REQUEST

Current Zoning: R-8MF(CD) (multi-family, conditional)
 Proposed Zoning: N1-A(CD) (neighborhood 1-A, conditional)

Approximately 26.17 acres located on the west side of Beatties Ford Road and north side of Kidd Lane, south of Miranda Road.

The petition proposes to develop a residential subdivision made up of single-family, duplex, and triplex dwellings on a site currently developed with two single-family houses.

RZ-1

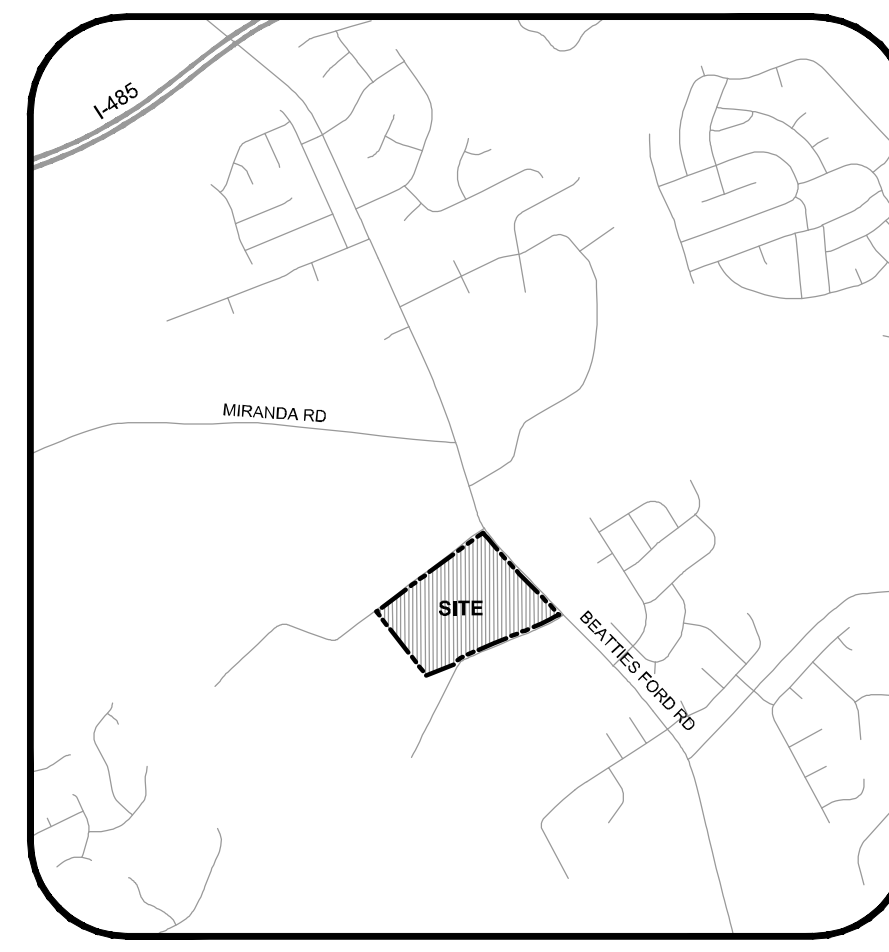
2. Urban Forestry: Tree Survey for Conditional Zoning Map Amendment. A tree survey shall be required for all conditional zoning map amendments.
3. Urban Forestry: Show green area calculations. It does not appear that enough tree save is being set aside.

8. Entitlement Services: Clearly show that the plan meets all Common Open Space and Green Area requirement for Compact Development.

9. Urban Forestry: for purposes of green area right-of-way for public street A, B and future Fred D Alexander are not to be deducted from calculations. Dedicated right-of-way along Cowboy Ln, Beatties Ford, and Kidd can be deducted.

SHEET NUMBER
RZ-2

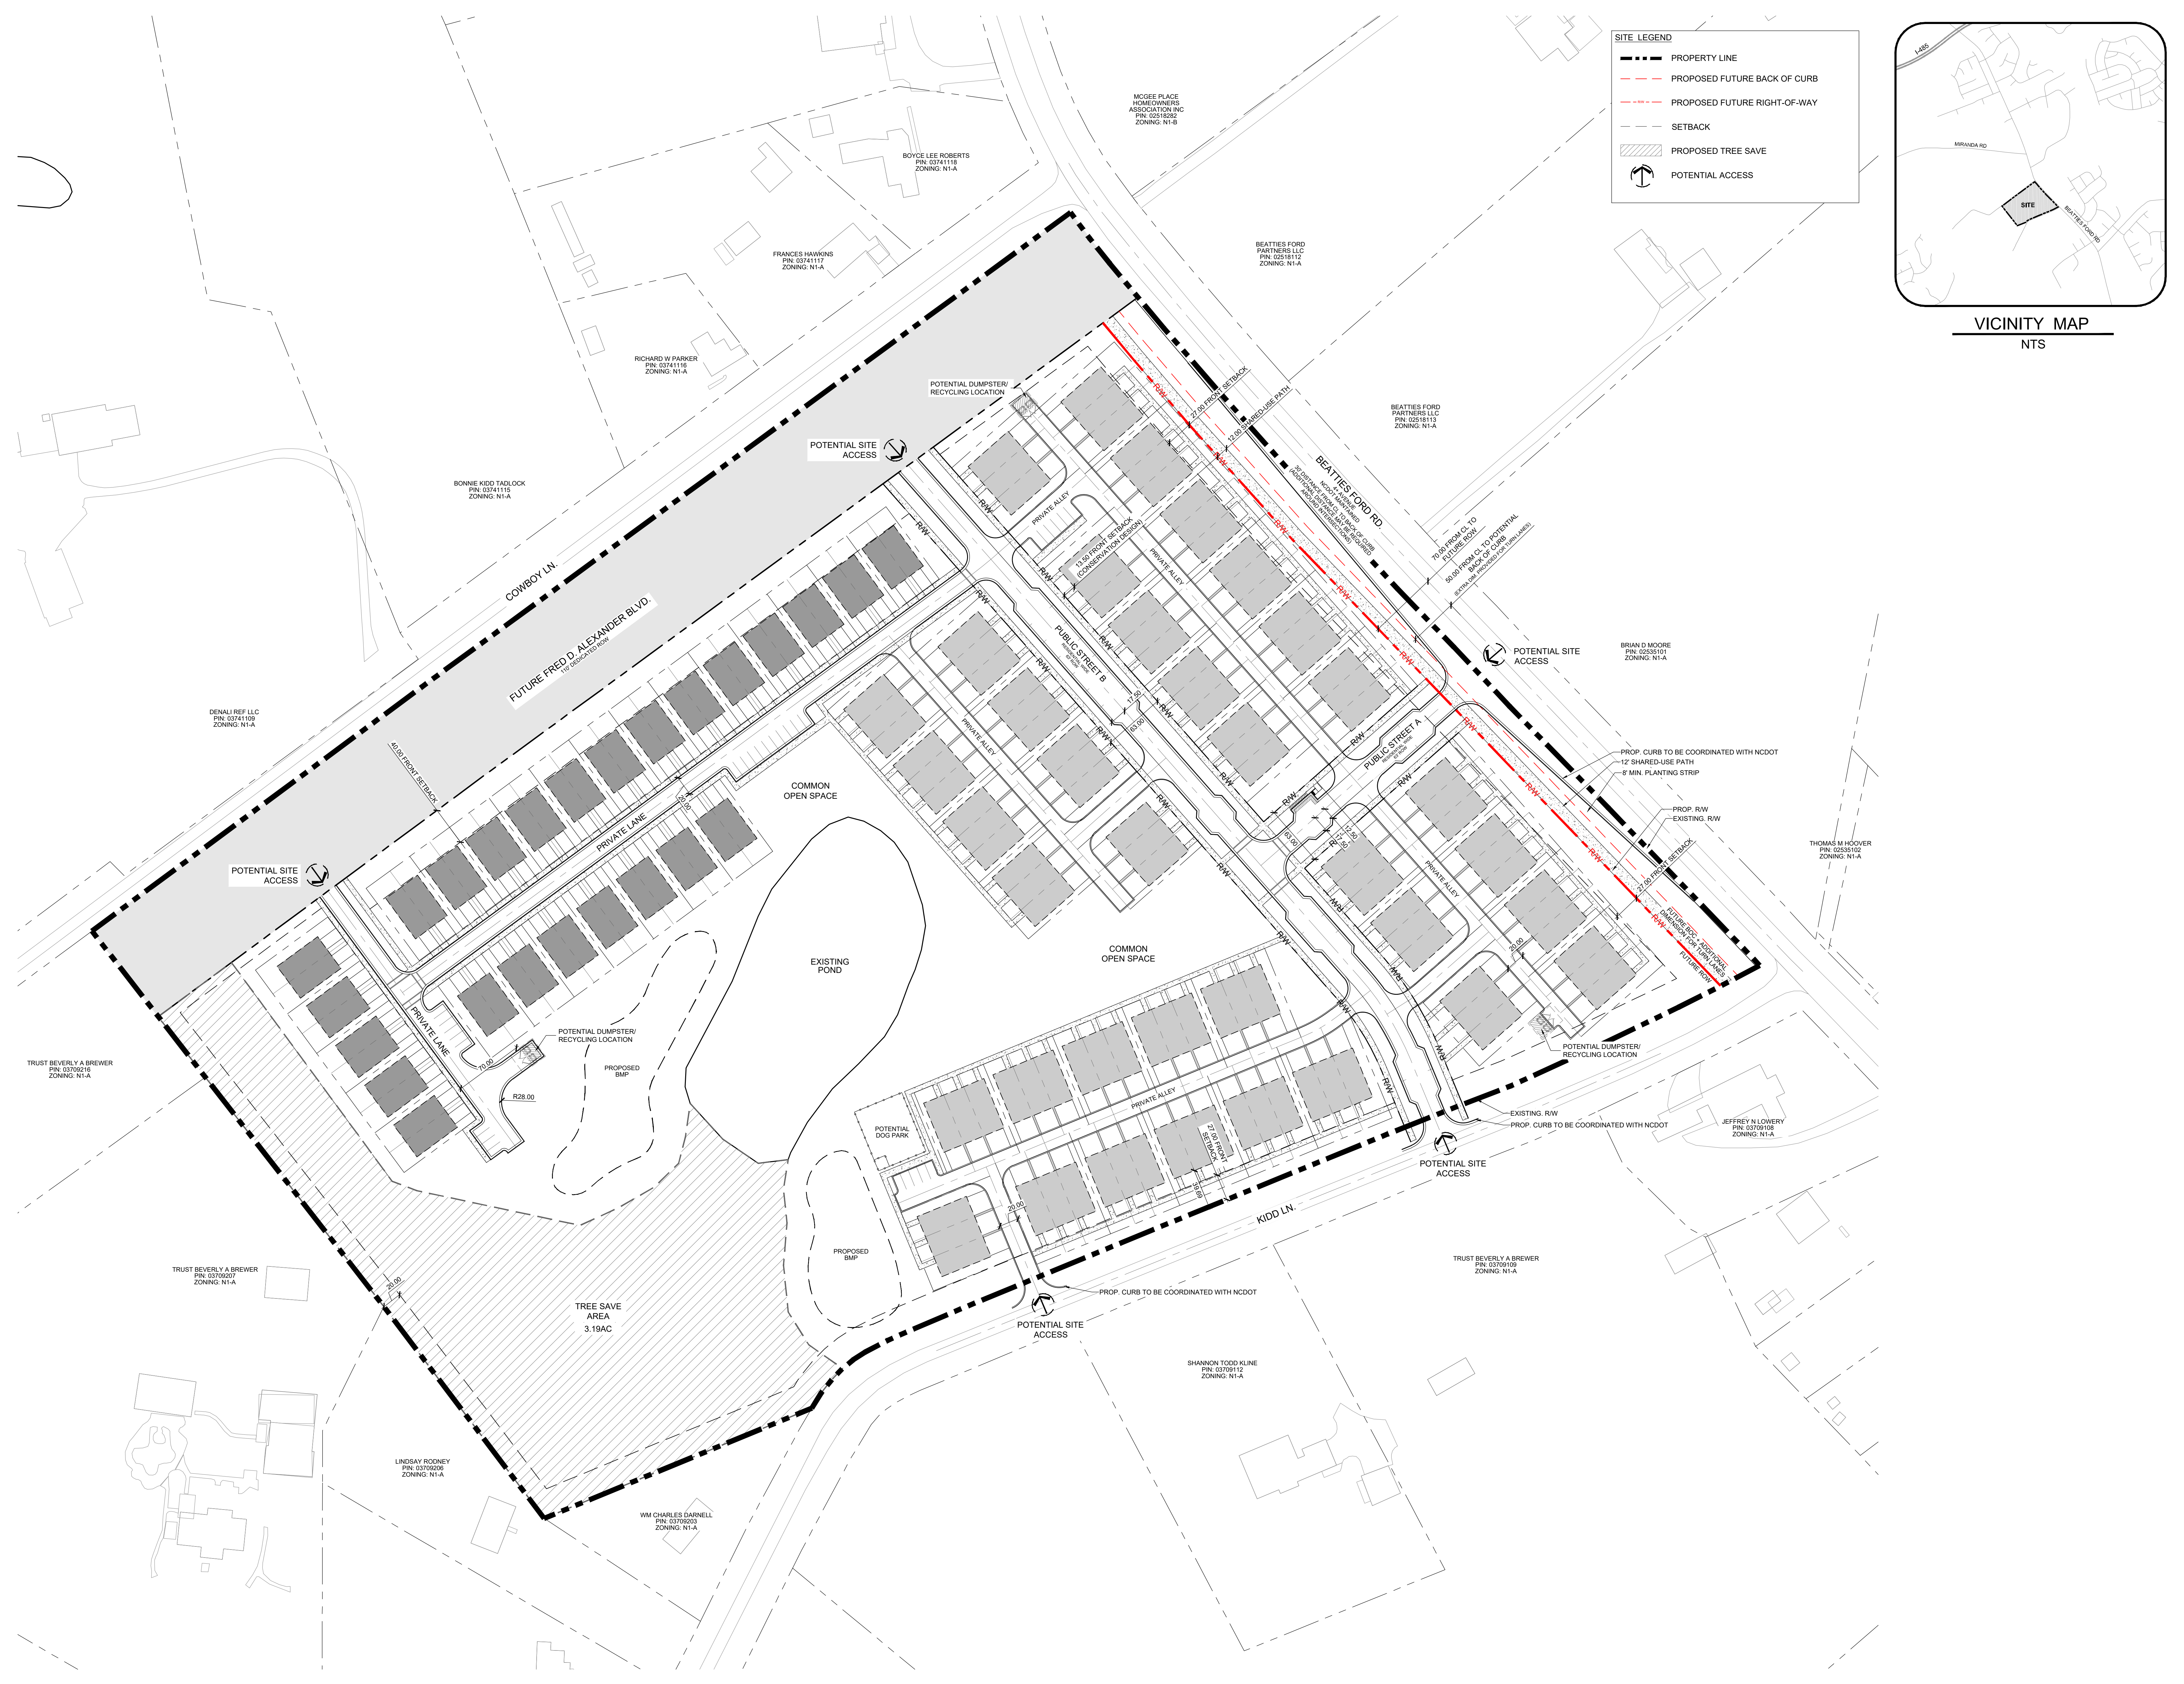
1. ~~CDOT: Site plan and conditional notes should be updated to construct streetscape the entirety of property boundary/Right of way for Kidd Lane and Cowboy Lane as well. Current plan had streetscape stopping short. Continue with streetscape along the entire property boundary for Kidd Lane as shown. Current site plan shows streetscape in its previously proposed location.~~ **Addressed**

4. ~~Subdivision: The new street network exceeds the maximum block length of 800'. Revise site plan to meet all subdivision requirements.~~ **Addressed**

10. ~~Entitlement Services: show required/proposed setbacks along all existing and proposed public and network require private streets.~~ **Addressed**
